Recommendation Report for Planning Permission for Works or Extension to a Dwelling**REF NO:** EP/83/14/HH**LOCATION:** Middle Barn
The Street
East Preston**PROPOSAL:** New driveway and vehicular access to eastern boundary of property.
Resubmission following EP/143/13.**SITE AND SURROUNDINGS**

PROPOSED LAYOUT 1:100

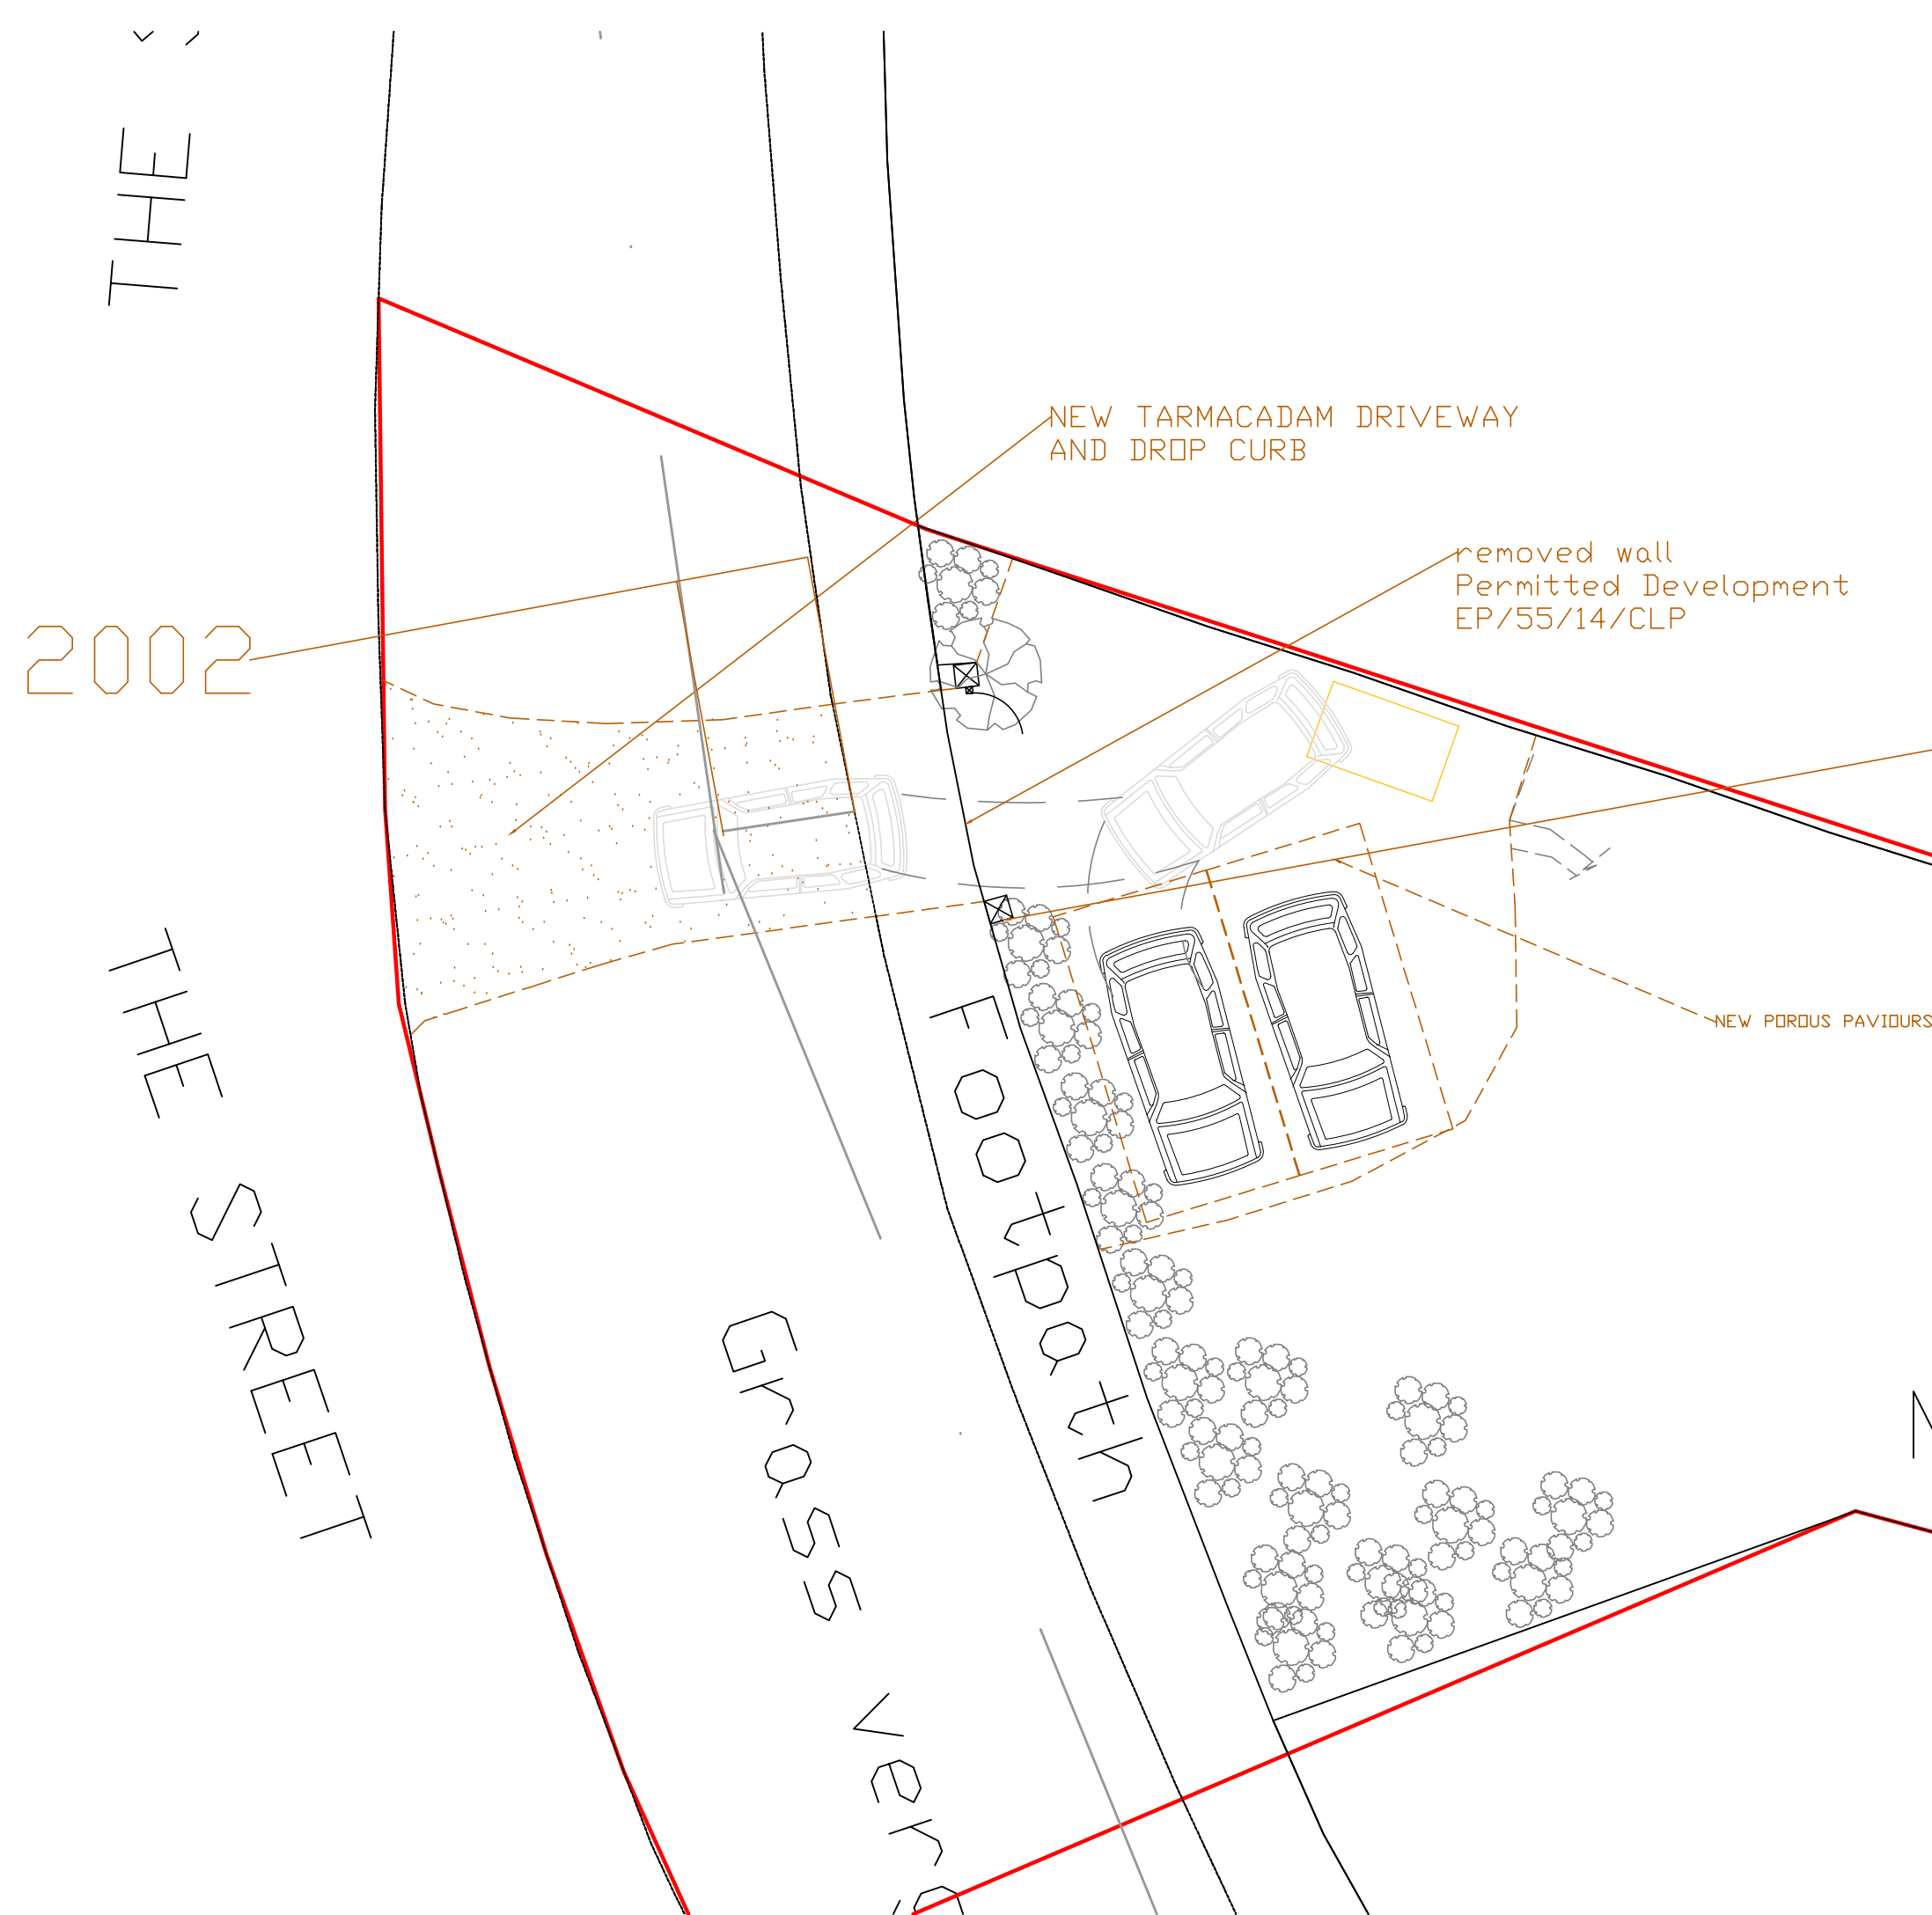
- Erosion of the grass verge within the village. The property is located within Character Area Three in the East Preston Village Design Statement and within this area, verges are reminders of the old village along roads must be preserved. It is therefore contrary to the village design statement.
- Middle Barn is on the Arun Buildings of Character (Local List) meaning planning permission should not be granted for an alteration that would adversely affect its appearance. The Committee feels a crossover may do just that and therefore should not be granted planning permission.
- The proposed location of the crossover would provide concerns about traffic exiting into The Street which is a busy road and a bus route.

Comments noted. In response, the proposed driveway in place of the grass verge will not cause any visual harm to the area due to its width of 5m which is comparatively small when set against the overall length of the grass verge at over 60m. Whilst the grass verge has special mention within Character Area Three of the East Preston Village Design Statement, the nature of the driveway with its limited profile will not be unduly prominent in the street scene. Given the limited amount of hard surfacing and the significant distance away from the host property, the proposal will not cause any unacceptable harm to the Building of Special Character. It will be similar in appearance to the existing driveway to the south particularly in its use of tarmac cutting across the grass verge. West Sussex County Council Highways department has no objection to the crossover from a highway safety perspective.

The proposed crossover will join on to The Street at a width of approximately 5.2m with a tarmac driveway in place of an existing grass verge. The driveway and dropped kerb will not cause any harm to visual amenity due to the limited profile of the driveway and the residential character of the road which this proposal is considered to be consistent with. It will also be similar in appearance to the existing vehicular access to the south which also comprises of tarmac that bisects the grass verge. As well as this area of tarmac the nearby properties enjoy paved crossovers and the proposal will not be out of keeping.

- 3 No works shall commence until details have been submitted to and approved by the Local Planning Authority for the drainage measures and materials used in the construction of the crossover and hardstanding area and shall thereafter be implemented and retained in perpetuity.

PROPOSED BLOCK & LAYOUT 1:500

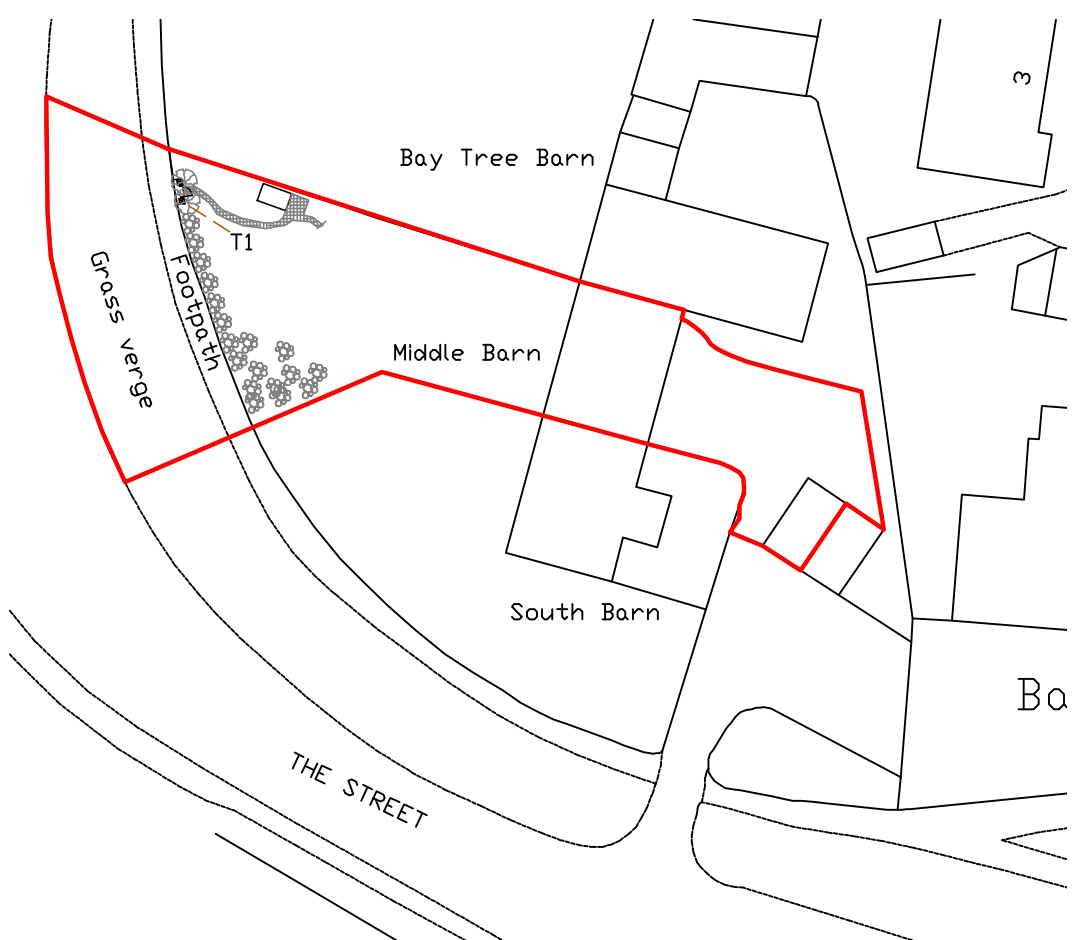
Previous application EP/55/14/CLP has determined that the removal of the flint wall, gate and fence as shown in the submitted plans constitute Permitted Development and therefore are not for consideration here. There is an existing vehicular access and dropped kerb which forms a shared access to the property and the neighbouring property of South Barn. This is part tarmac and part gravel and is situated to the front of these properties. This proposal is for an additional vehicular access to the rear of Middle Barn which is less restrictive in turning and avoids using the shared driveway.

There will be no harmful residential effects created by the proposed with considerable distances between the proposed driveway and crossover and the neighbouring properties of Bay Tree Barn and South Barn.
